Application for a non-material amendment following a grant of planning permission.  
Town and Country Planning Act 1990

House name: **FORMER MOORCOCK INN SITE**

CONSTRUCTION OF FOUR DWELLINGS INCLUDING ASSOCIATED DRIVES,  
GARDENS AND EXTERNAL LANDSCAPE WORKS

3/2018/0344

5513 - P04C

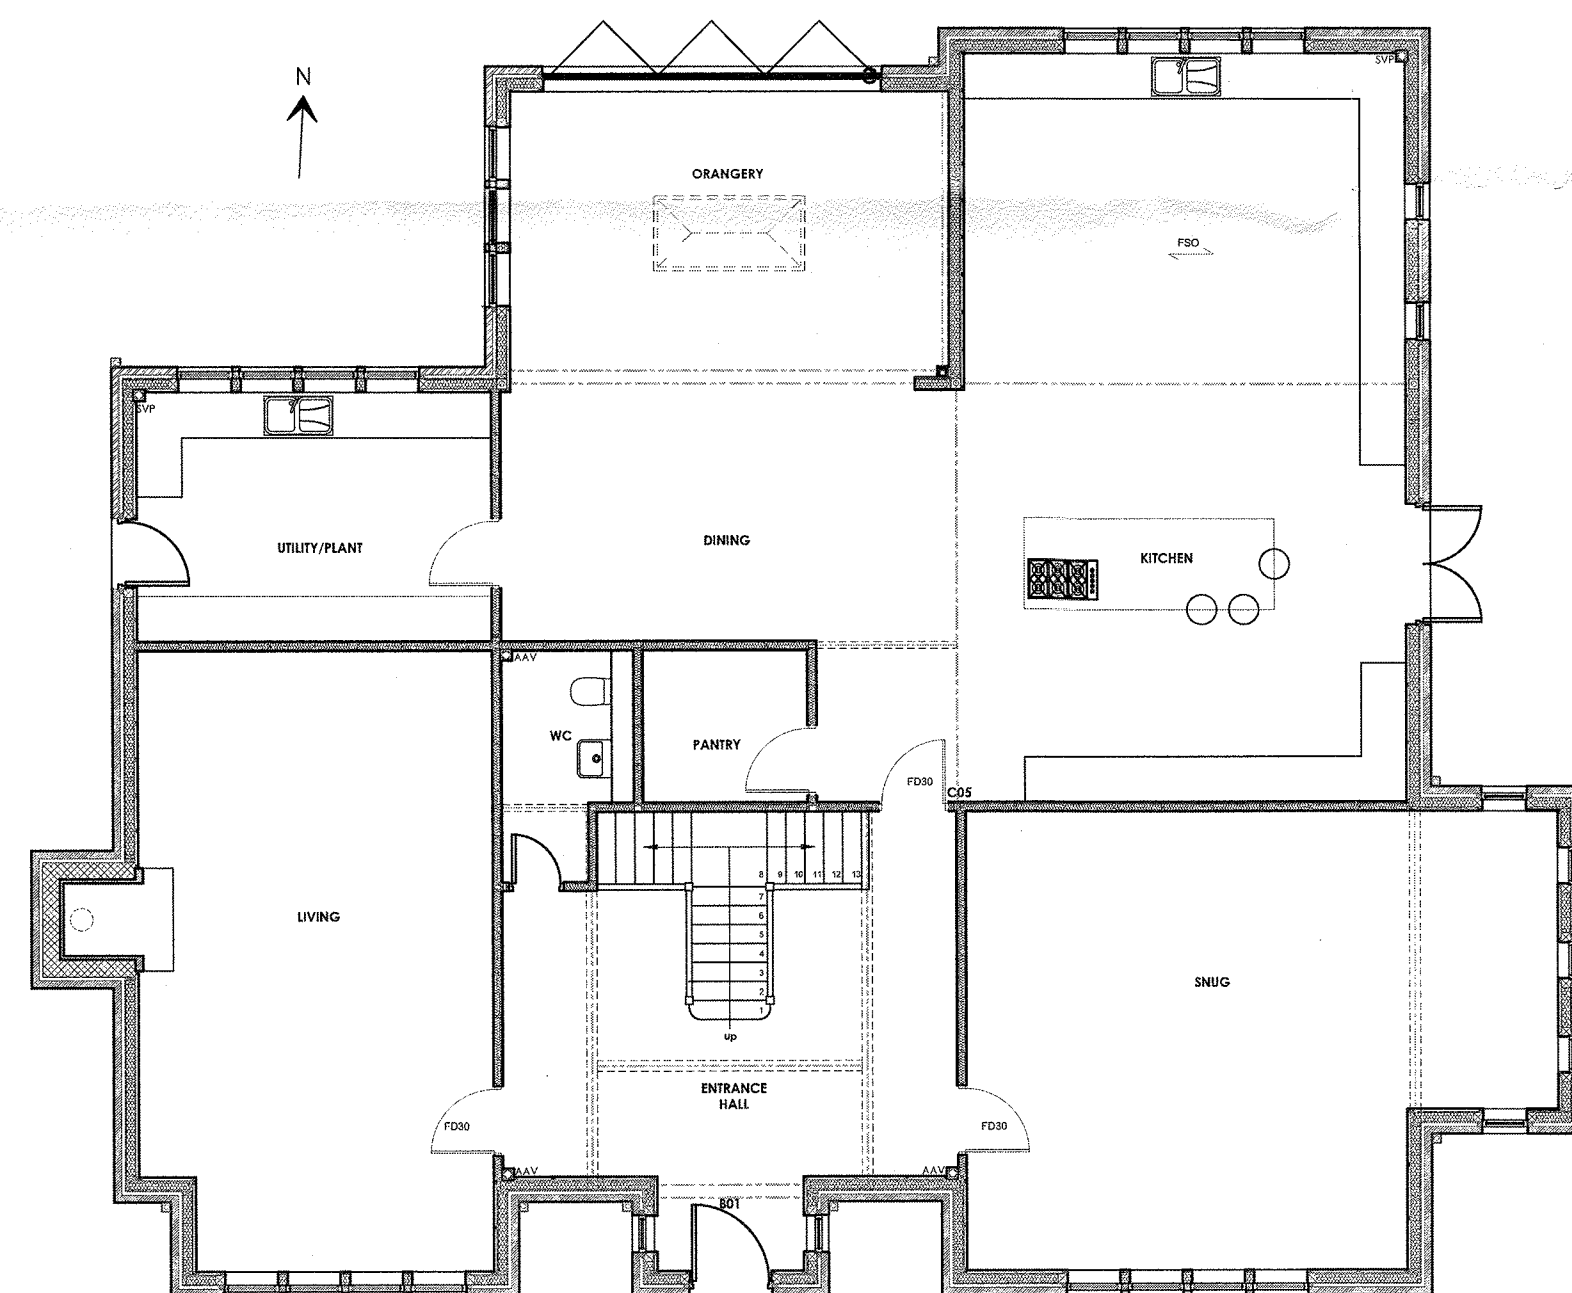
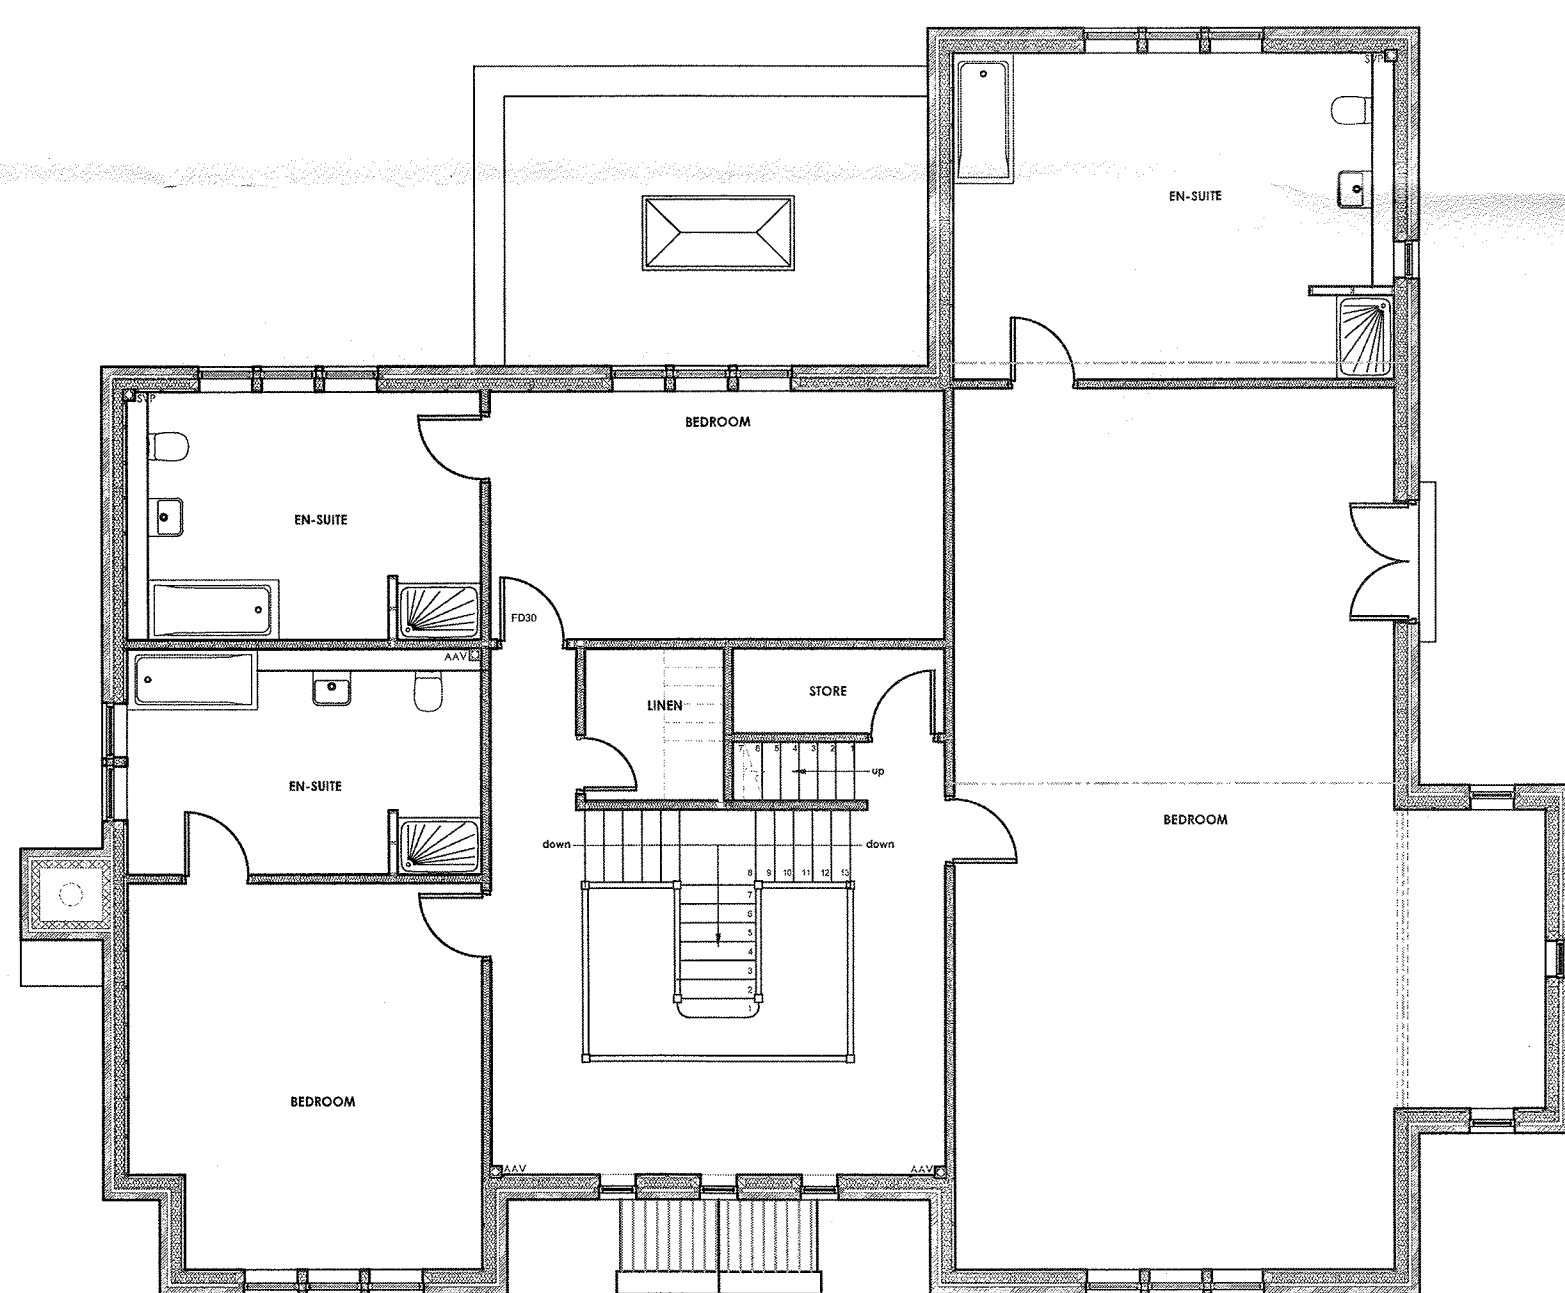
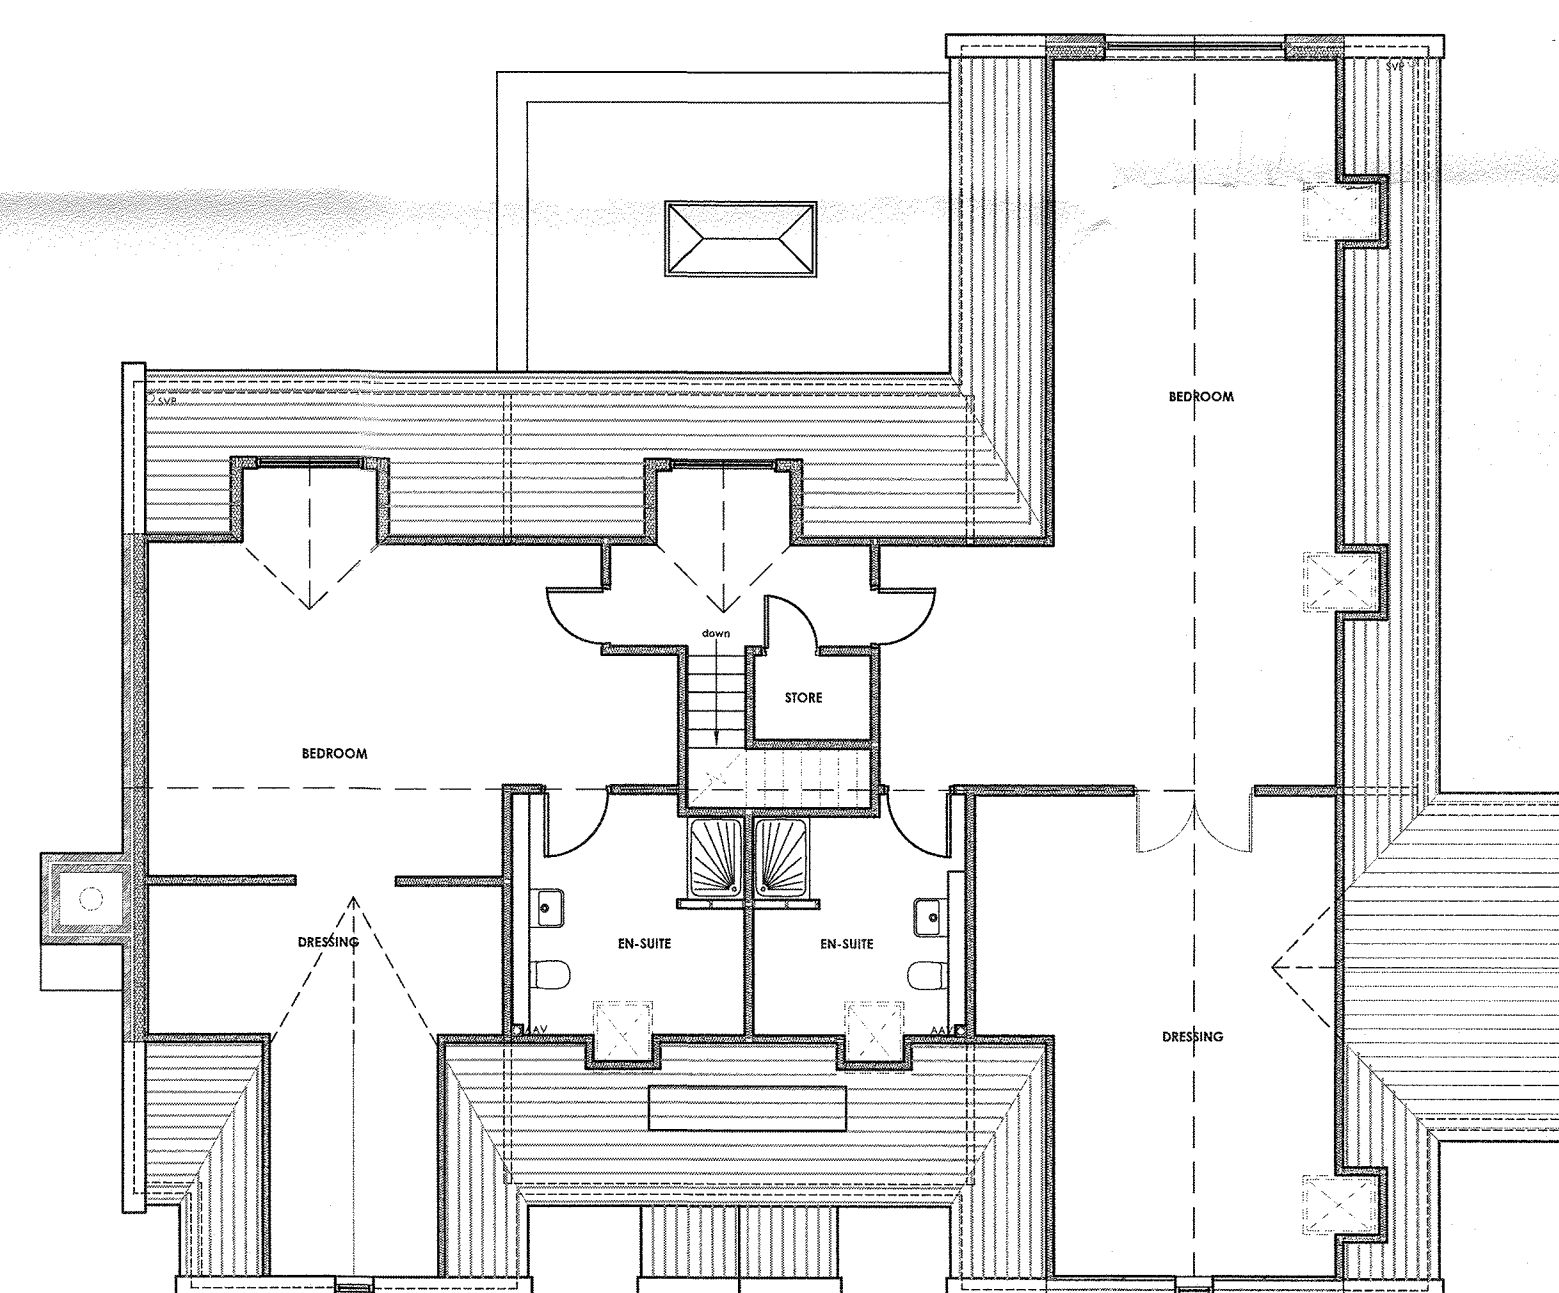
- PLOT 4:  
• WINDOWS ADDED TO THE FRONT GABLE  
• WINDOW ADDED TO EN-SUITE
- PLOT 3:  
• WINDOWS ADDED TO THE FRONT GABLE  
• WINDOW ADDED TO EN-SUITE
- PLOT 2:  
• WINDOW ADDED TO EN-SUITE

WINDOWS REQUIRED TO MAXIMISE VIEWS  
AND ADD ADDITIONAL NATURAL LIGHT INTO THE  
DWELLINGS
